Please ask for: Ms Iqraa Malik
Email: iqraa.malik@terraquest.co.uk
Telephone: 01212341390
Our Ref: BR/136/20/HH
Your Ref:
Date: 1st July 2020

Application for Planning Permission for Works or Extension to a Dwelling

Development: Single storey extension to front.
Location: 19 Ivy Crescent Bognor Regis PO22 8AB

PROPOSED ELEVATIONS

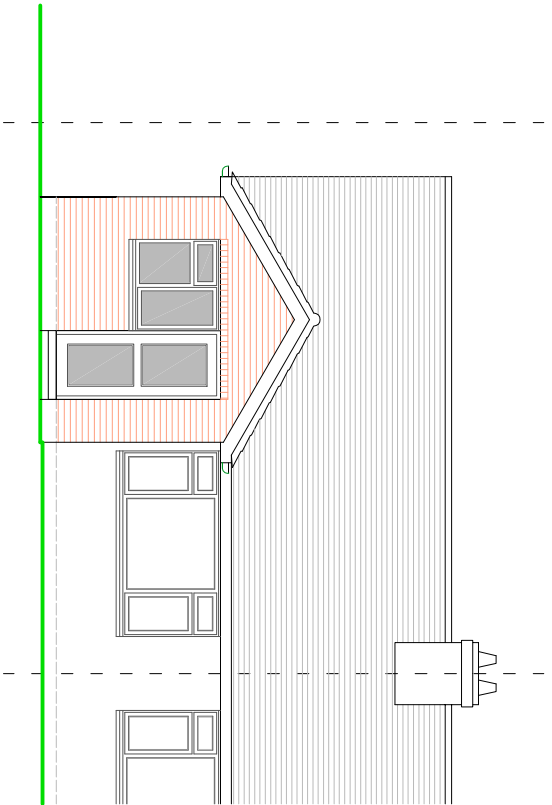
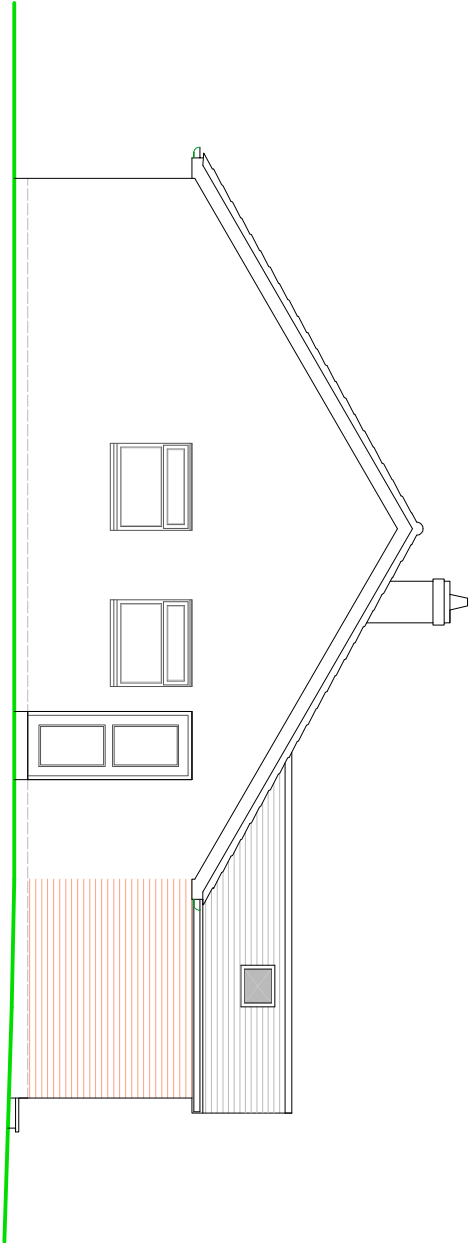
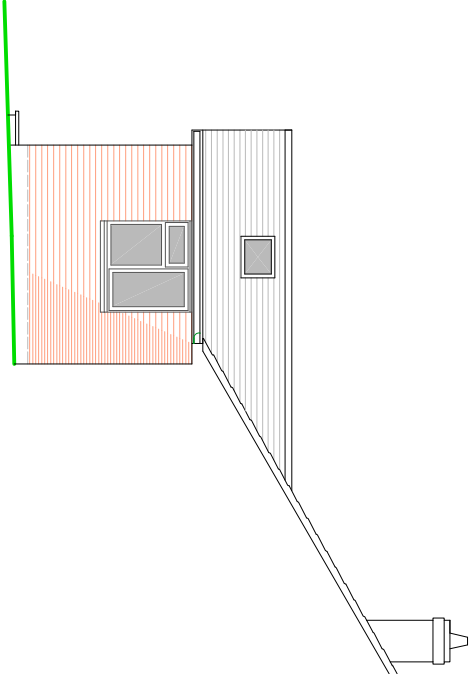
Labels: The proposed elevations have been labelled existing. Please amend.
